CHENNAI METROPOLITAN DEVELOPMENT AUTHORITY

File No. : CMDA/PP/NHRB/C/0791/2019

Sub : CMDA-Area plans Unit - 'B' Channel (Central) – The Planning Permission application received for the proposed construction of 1Parking + 9Floor Residential building with 6 dwelling units at Door No:C79/ A1,A2,,Plot No:C79/A1,A2,Address:86th Street, 18TH Avenue,,Locality:Ashok Nagar,City/Town:CHENNAI in S.No. 70 TS.No. 11 of Kodambakkam village within the limit of Greater Chennai Corporation Particulars called for - Reg

PARKING

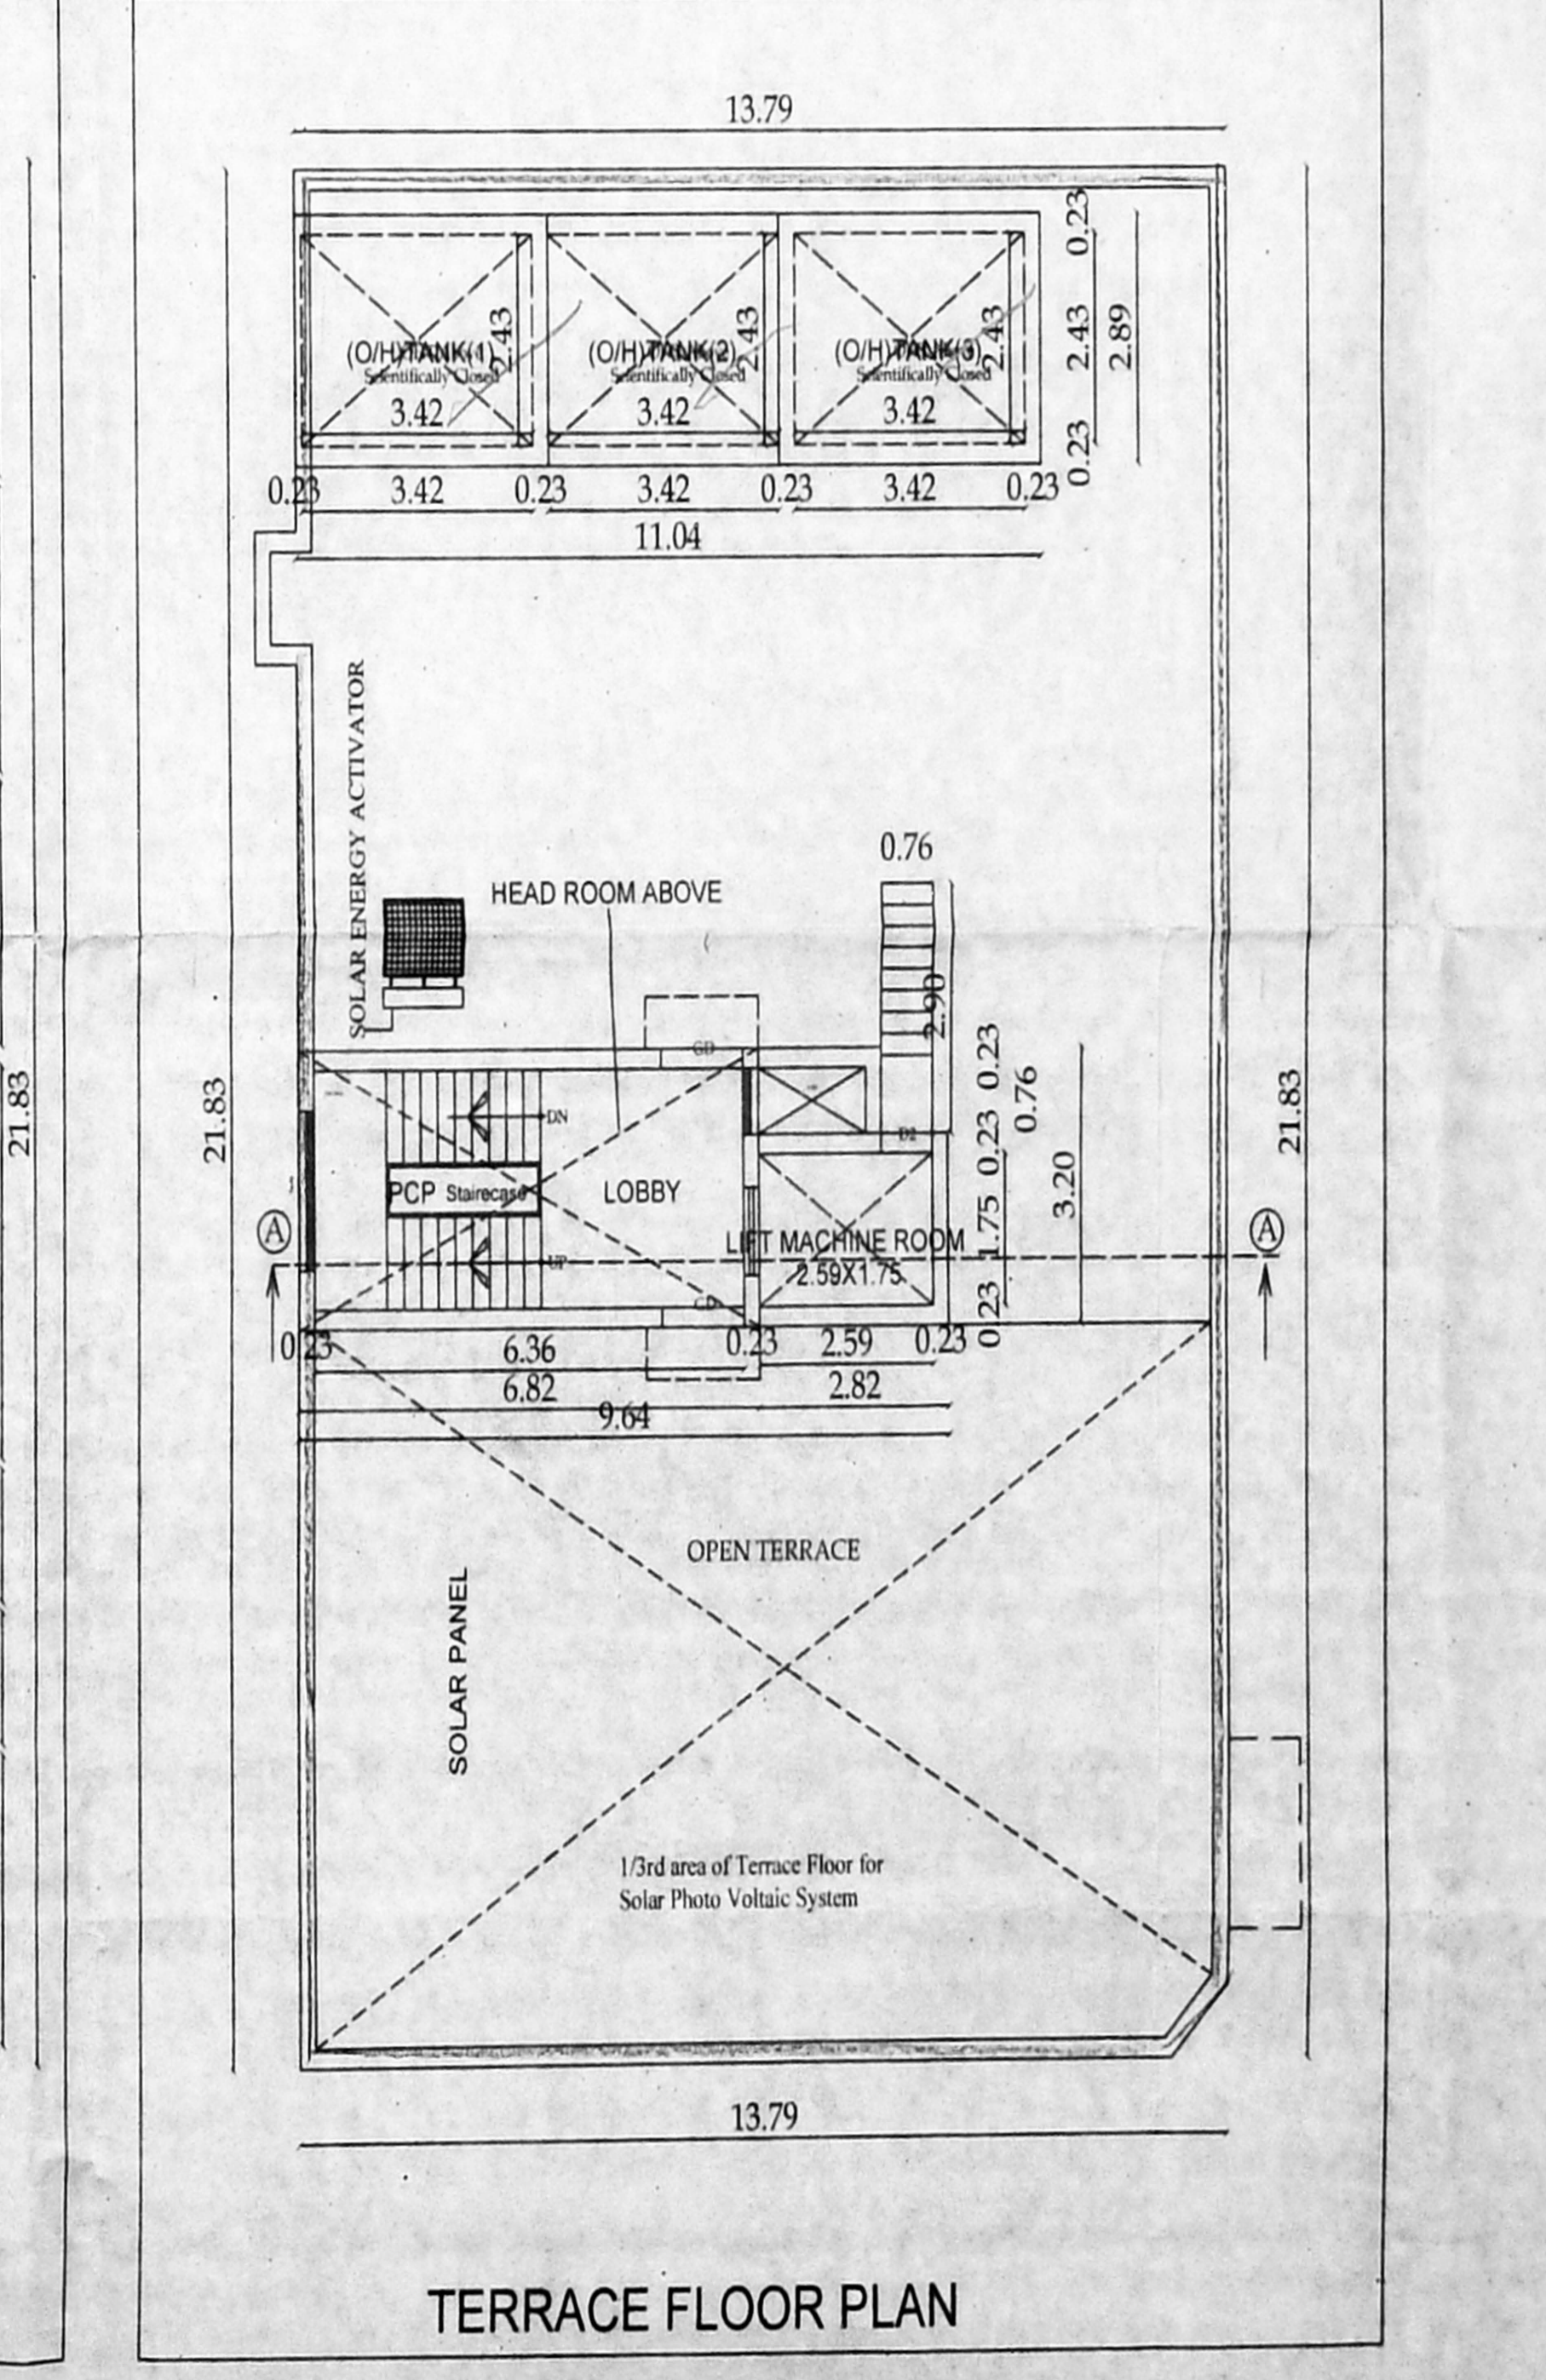
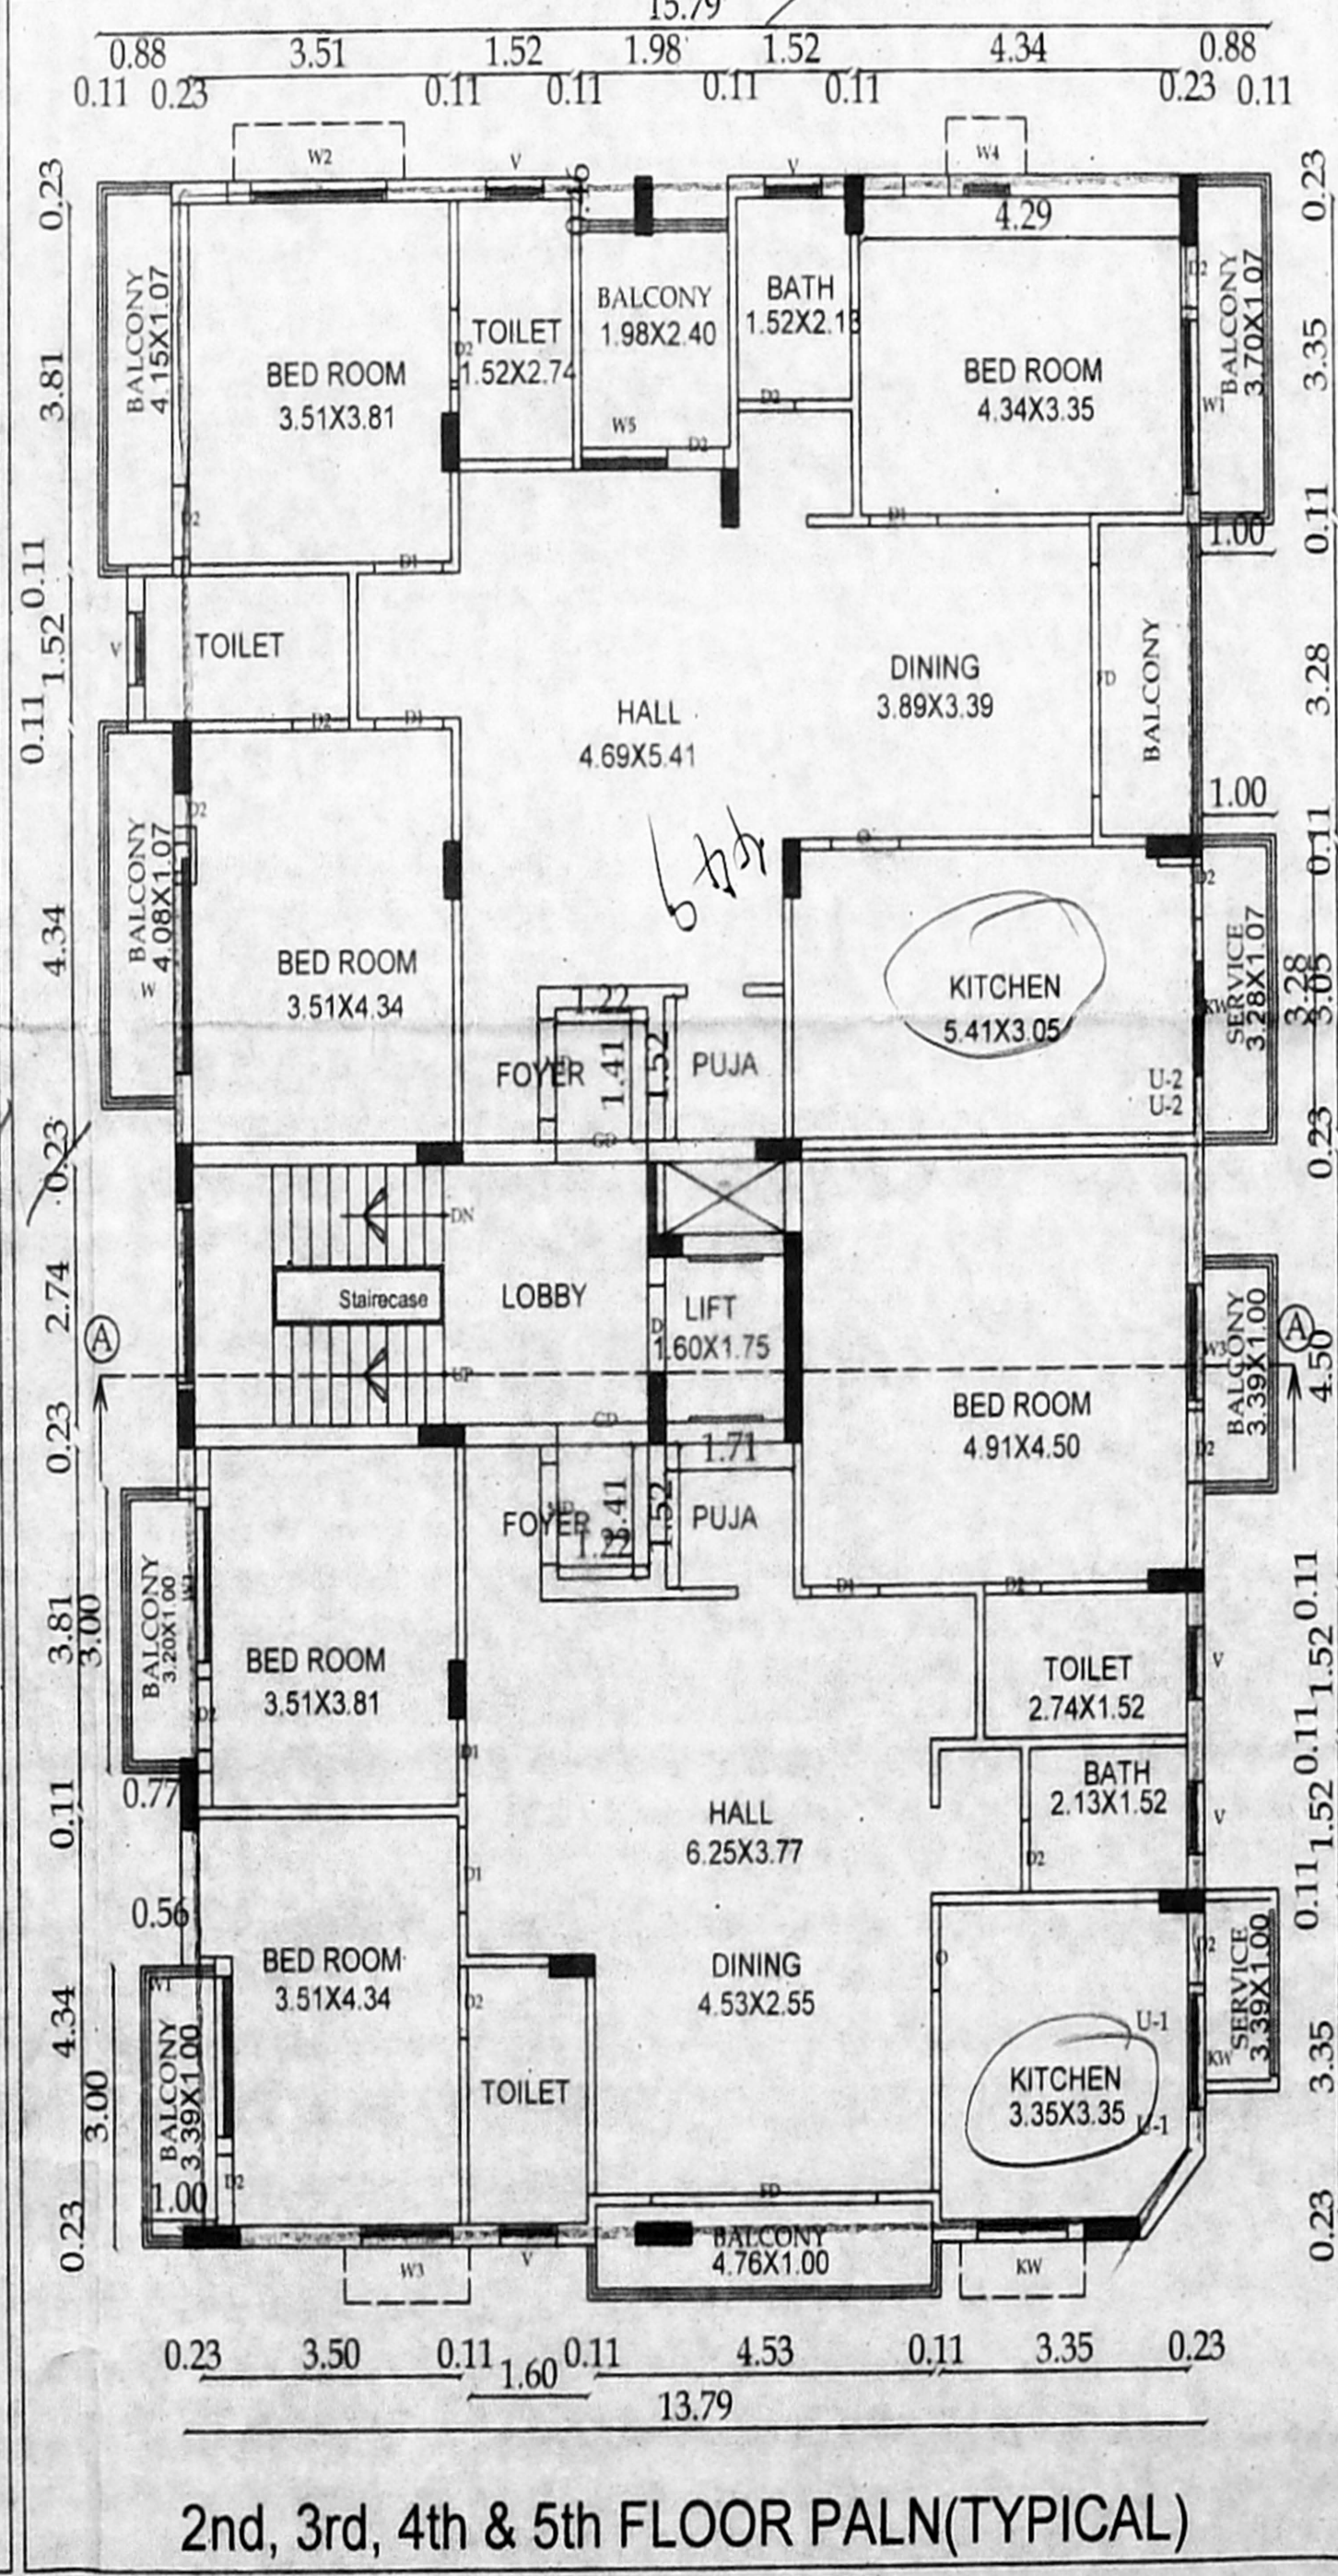
- 1.17 Nos of Car parking 13 Nos of T.W.Parking to be shown correctly
- 2.Title and Area statement to be shown correctly.
- 3.Setback details to be shown correctly.
